From: Laura Gibbons
Sent: 24 July 2019 16:00
To: Richard Castro-Parker
Subject: RE: BE/139/18/PL - Innovation Centre Beeding Close
Attachments: RE: BE/139/18/PL - Innovation Centre Beeding Close

It has been drawn to my attention that further details regarding drainage at BE/139/18/PL - Innovation Centre Beeding Close had been sent to Stuart Corbey a while back and then to me 24 June. Please see the attached Drainage Strategy re: BE/139/18/PL - Innovation Centre Beeding Close. Additionally, It has been drawn to my attention today (24/07/2019) that the B2 building has already been built and that the agent/applicant feels that:

Please can the applicant submit clearer plans of the proposed surface water drainage arrangement. I.e. different line types used, rather than all very similar colours. Please can gullies, manholes, and linear drainage channels be clearly labelled.

- Proposed Drainage Layout – 1:100 Scale;
- Proposed Drainage Layout – 1:400 Scale.

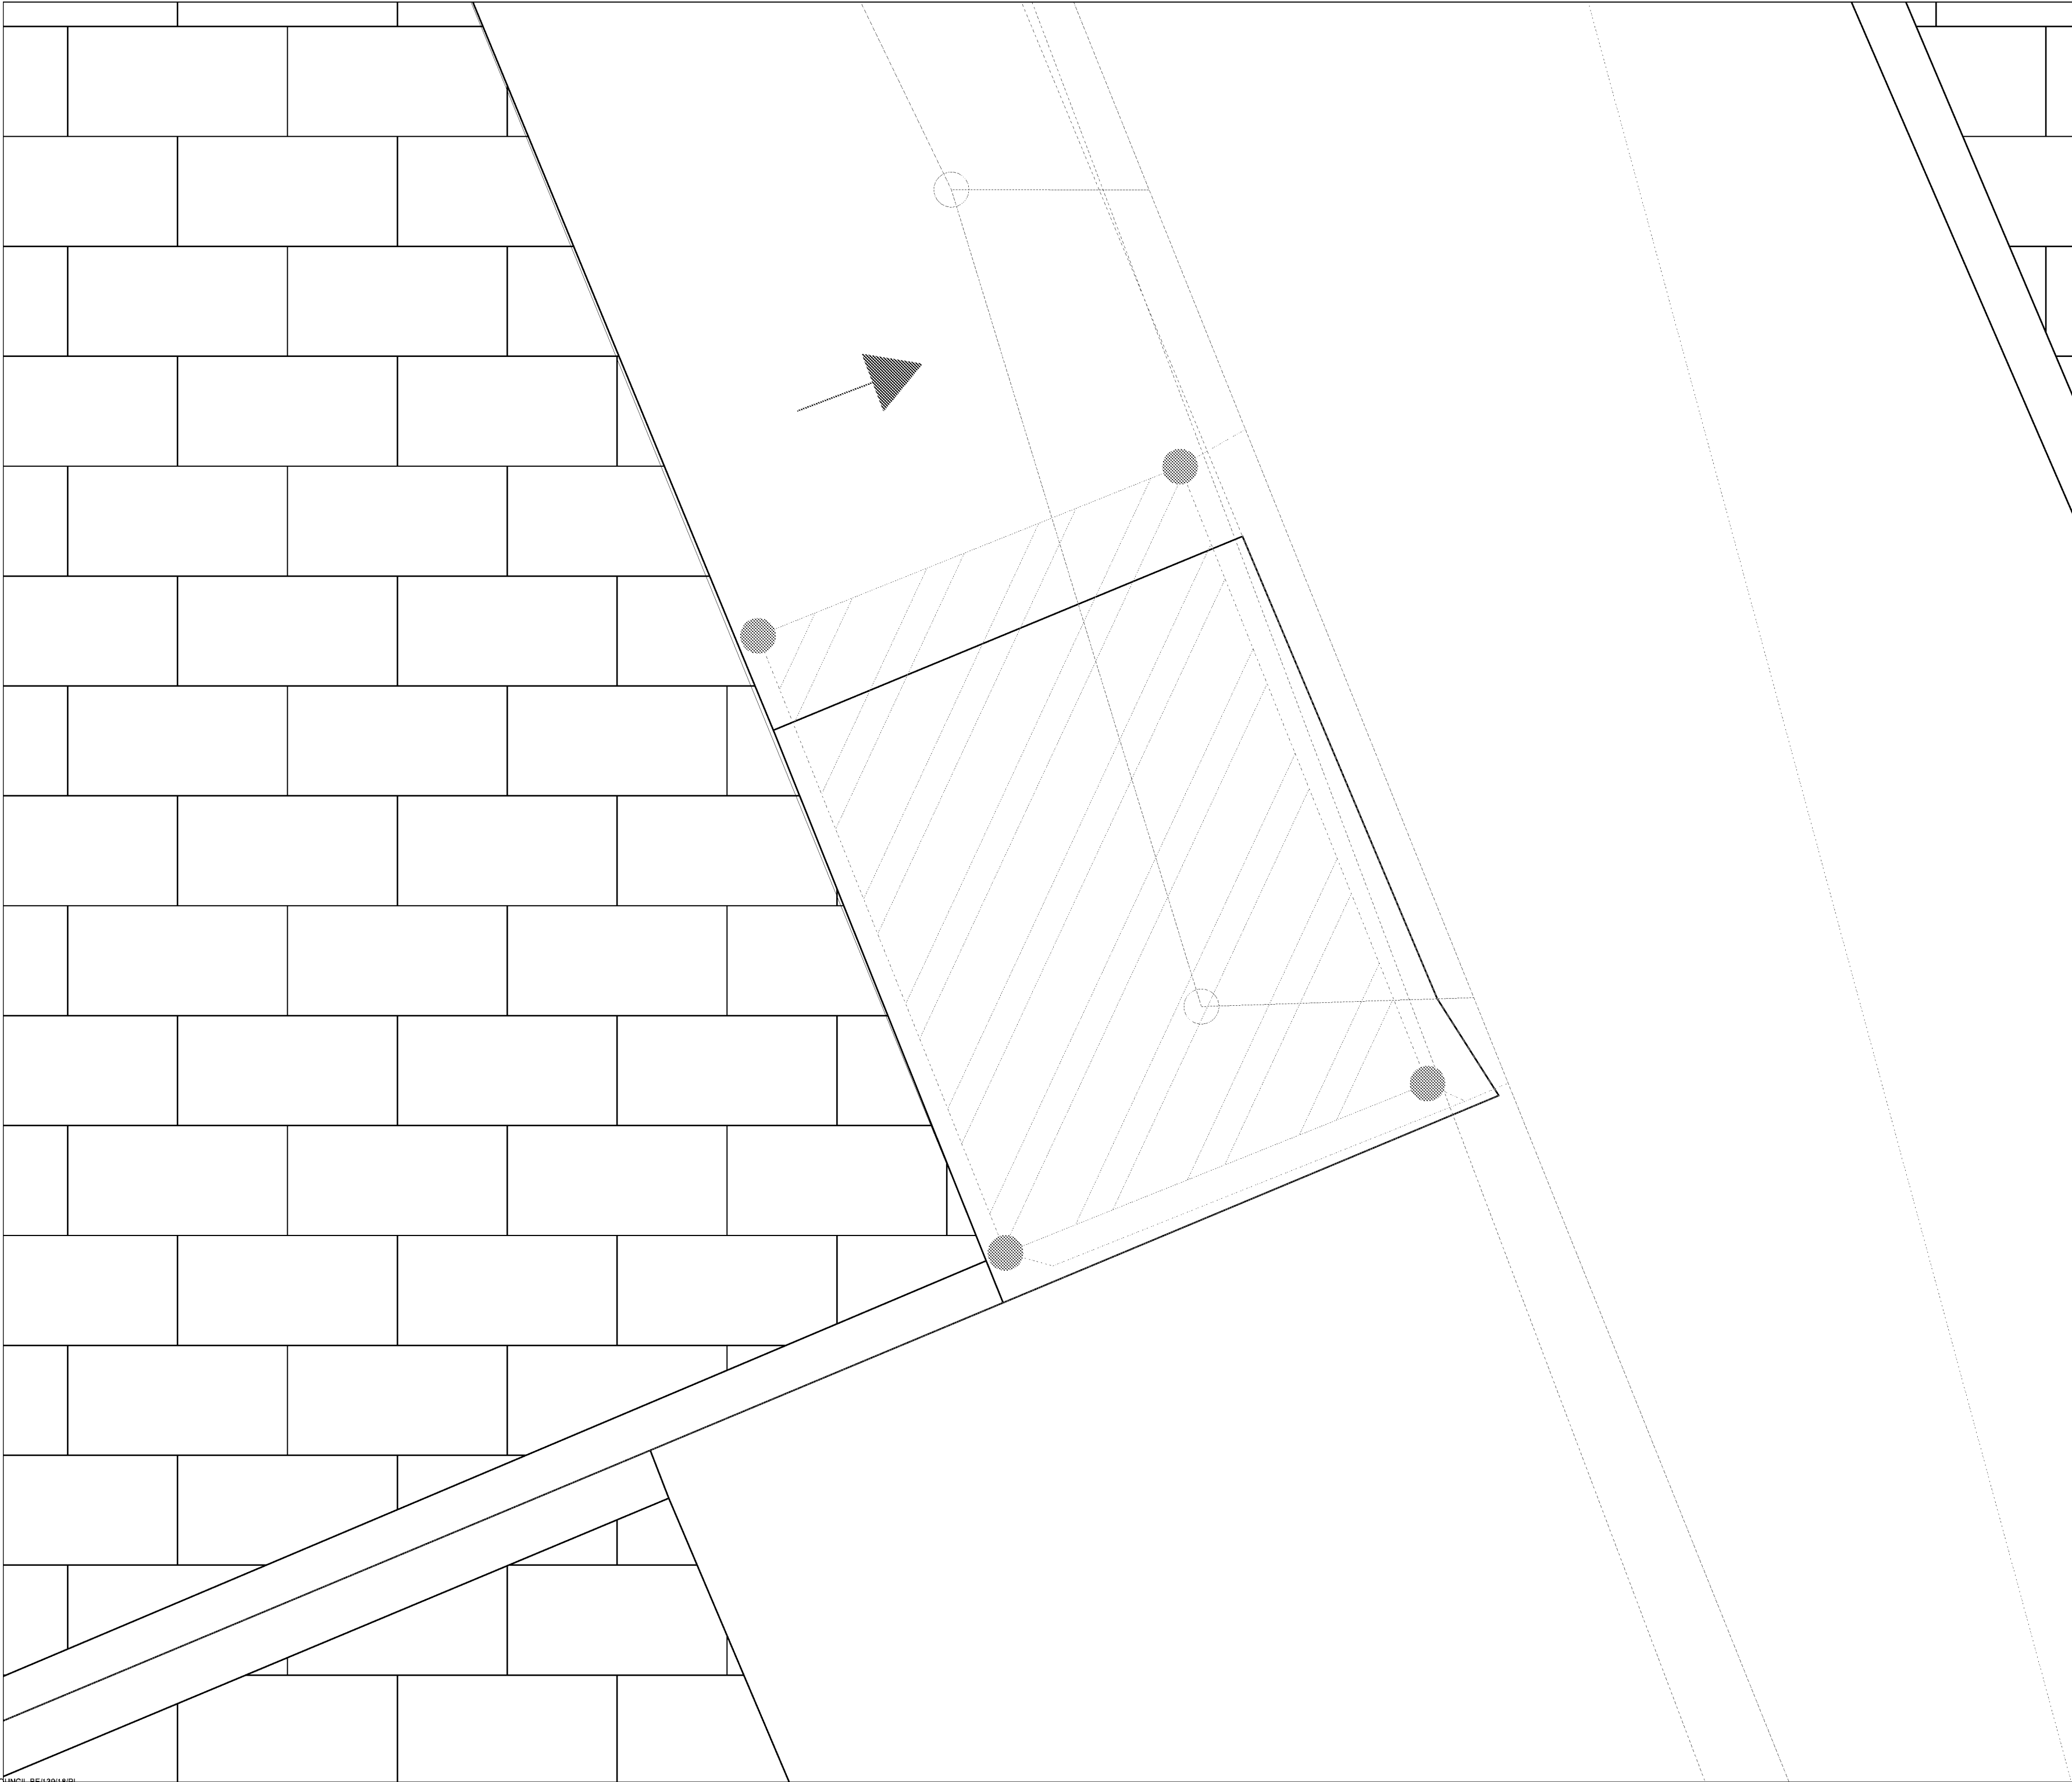
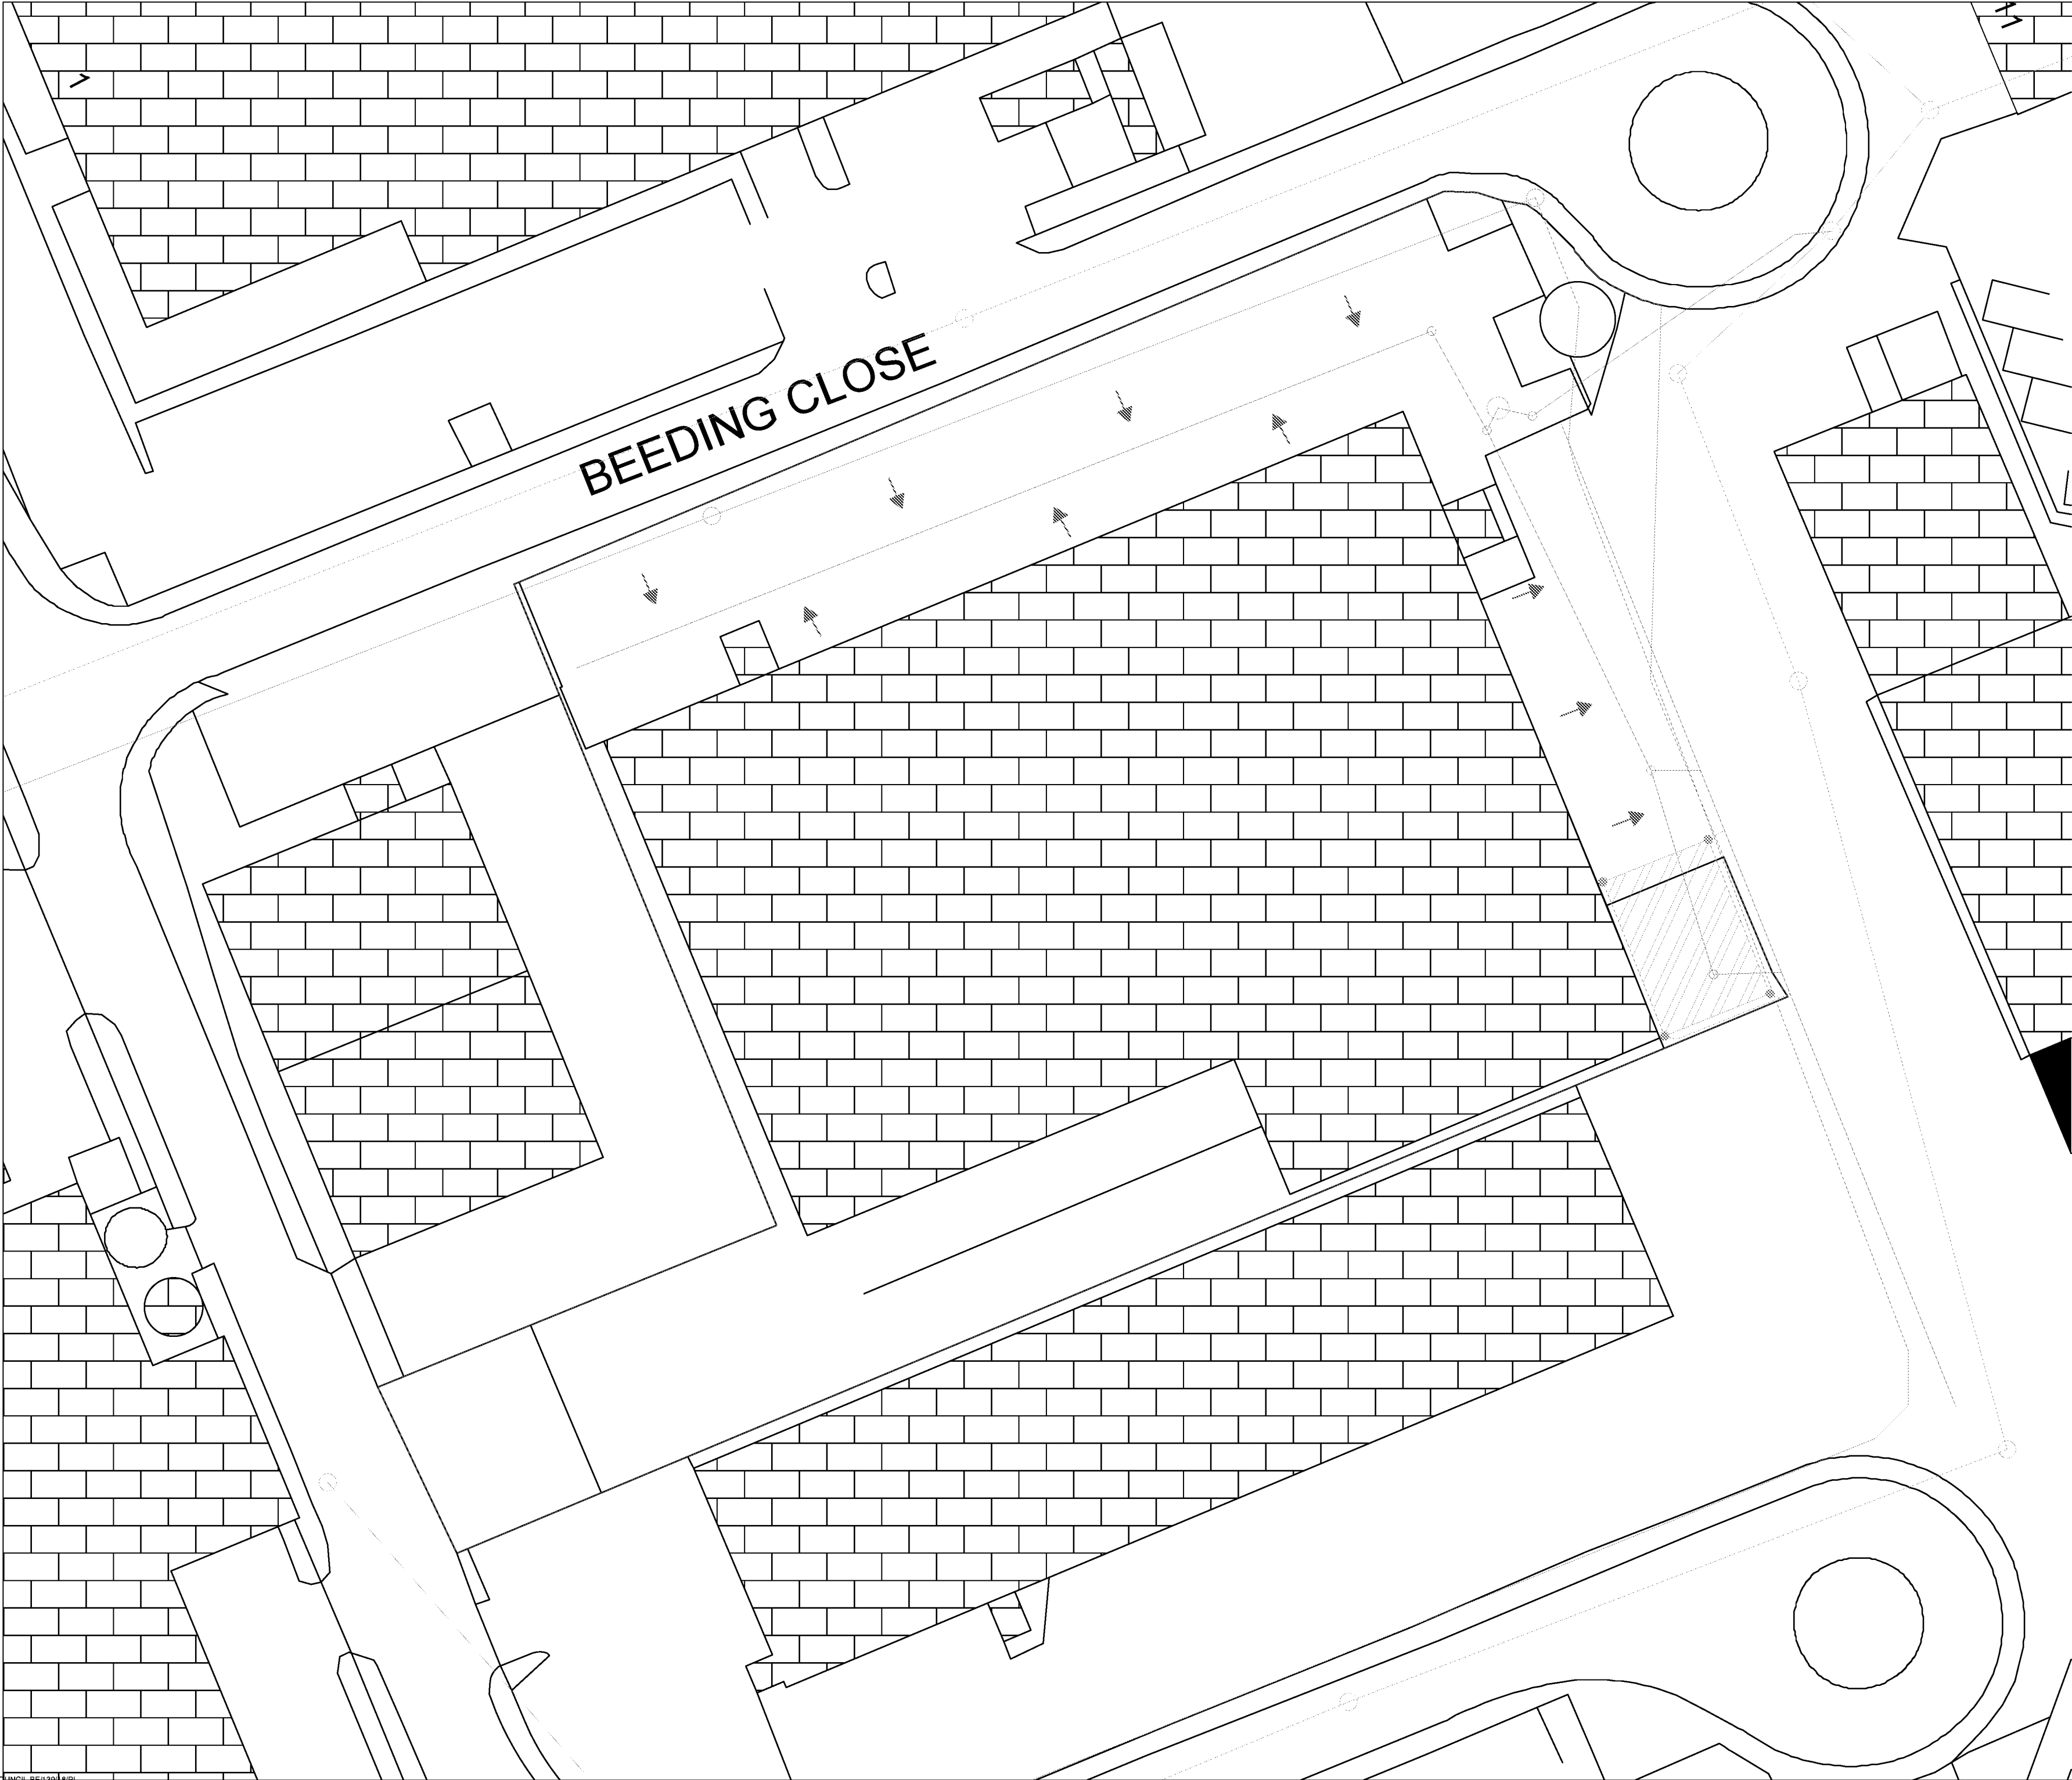
I also require levels to be submitted showing invert and cover levels of the existing drainage network and spot levels of the surrounding land. This is fundamental to ensure that the surface water from the development does not go off site.
